Inspector's Report ABP-303121-18

Whether installation of 3 no. windows on the east side elevation of the commercial farm machinery maintenance and sales building is or is not development and is or is not exempted development

Freighduff, Cashel, Co. Tipperary.

Window locations

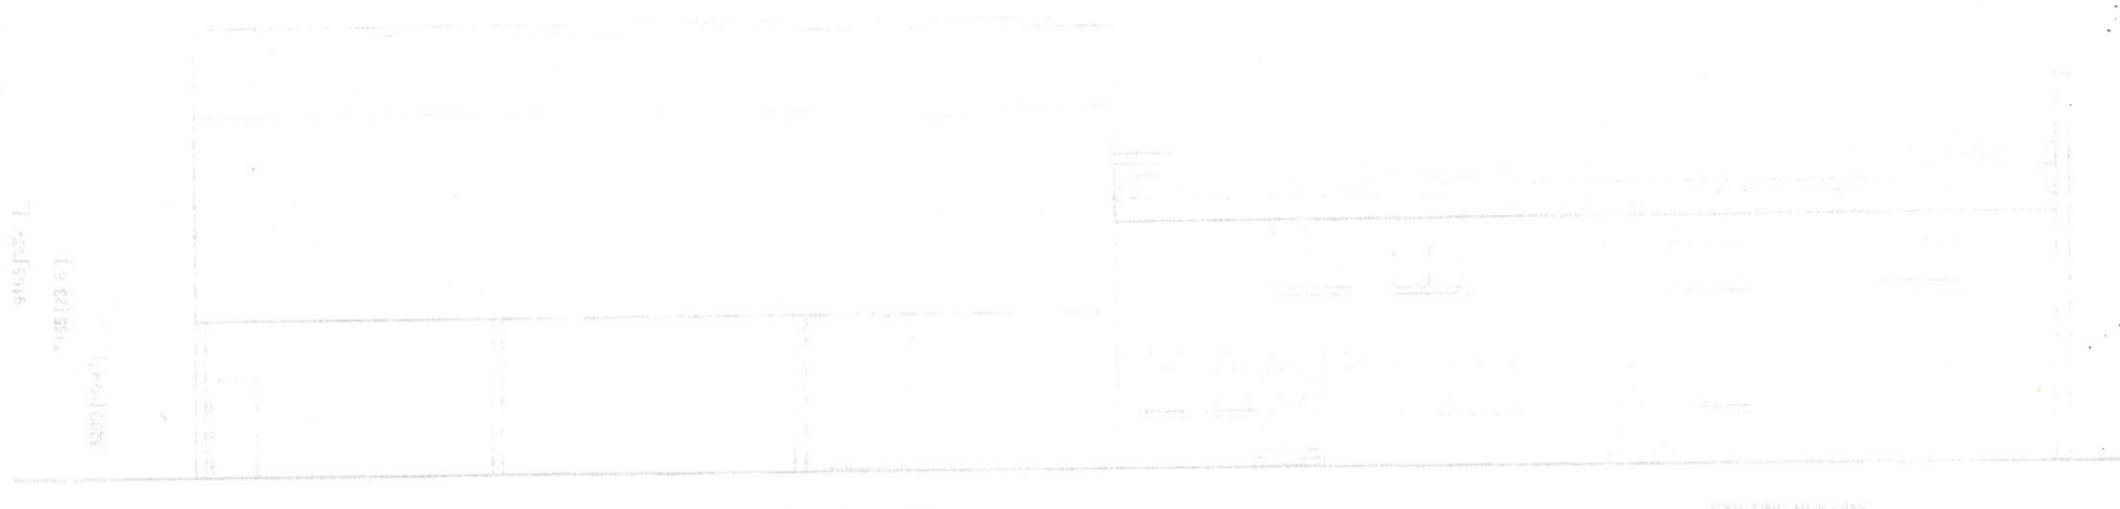
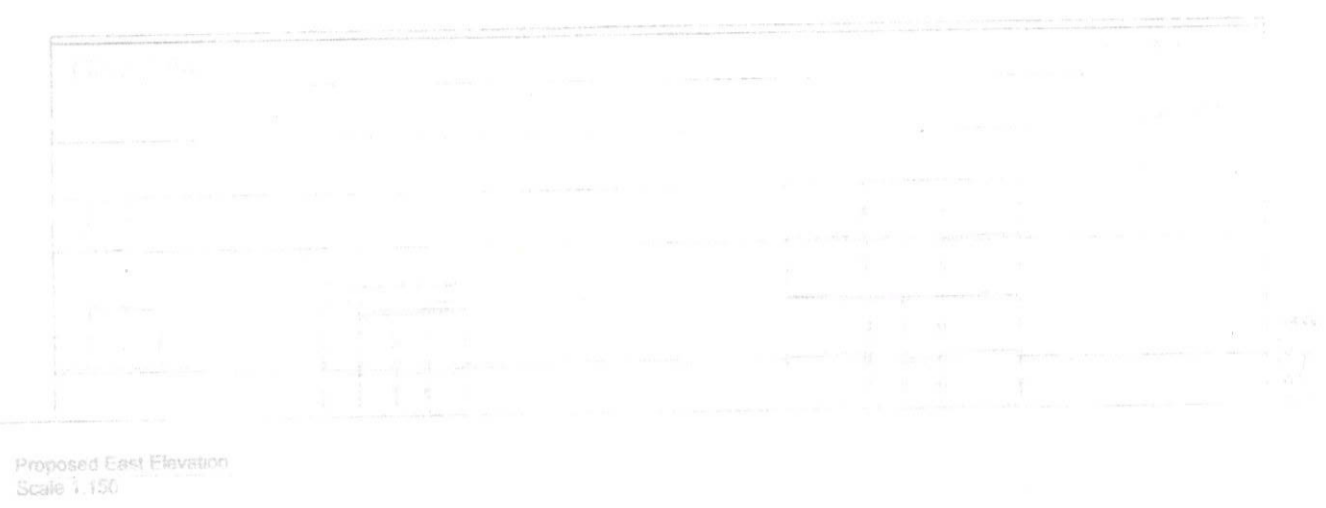
9.3.4 As noted earlier the proposal is the installation of 3 no. windows on the eastern elevation of an existing commercial building. The 3 no. windows do materially affect the external appearance of the structure. It is acknowledged that they do face a block wall along the eastern boundary of the site, but this does not mean that they do not materially affect the external appearance of the structure. I would consider that the works in question do materially affect the external appearance of the structure so as to render the appearance inconsistent with the character of the structure or of neighbouring structures. The works in question therefore do not constitute exempted development under Section 4(1)h of the Planning and Development Regulations, 2001 (as amended).

on the east side elevation of the commercial farm machinery maintenance and sales building is development and is not exempted development.

Windows installed in north elevation

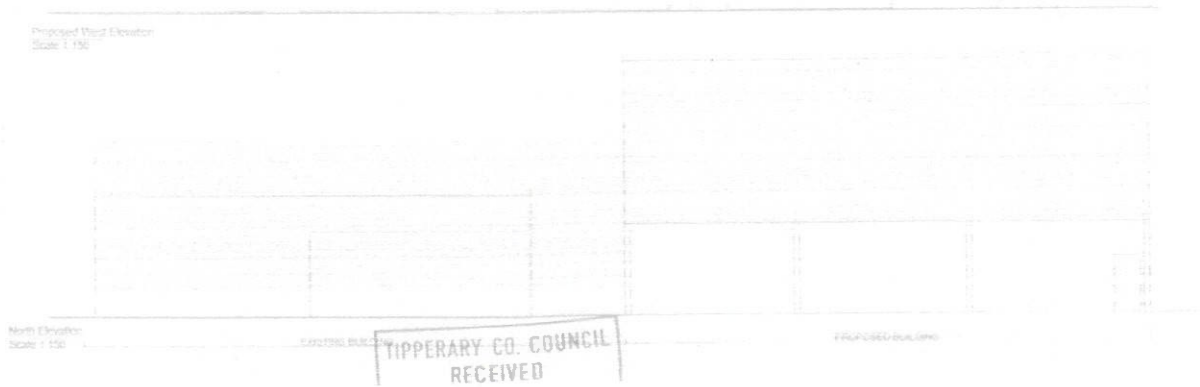
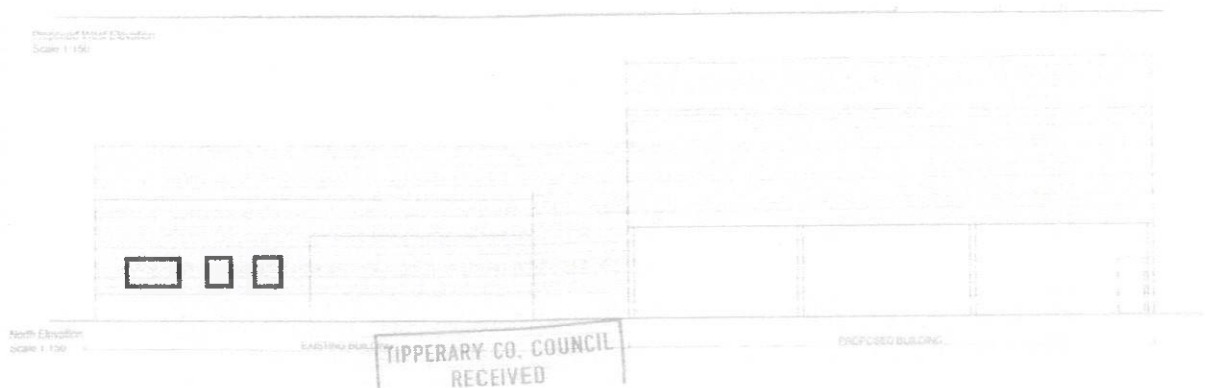
9.2.1 The initial question arises in relation to whether the installation of 3 no. windows on the east side elevation of the commercial farm machinery maintenance and sales building is or is not development. The construction subject to the referral includes the installation of 3 no. window openings in the eastern elevation of the existing commercial building. Section 3 defines development except where the context otherwise requires, the carrying out of any works on, in, over or under land or the making of any material change in the use of any structures or other land. Works as defined in section 2 (1) includes any act or operation of construction, excavation, demolition, extension, alteration, repair or renewal. Having regard to the definition of development and the nature of the works subject to the referral I would consider that the installation of the 3 no. windows constitutes development.
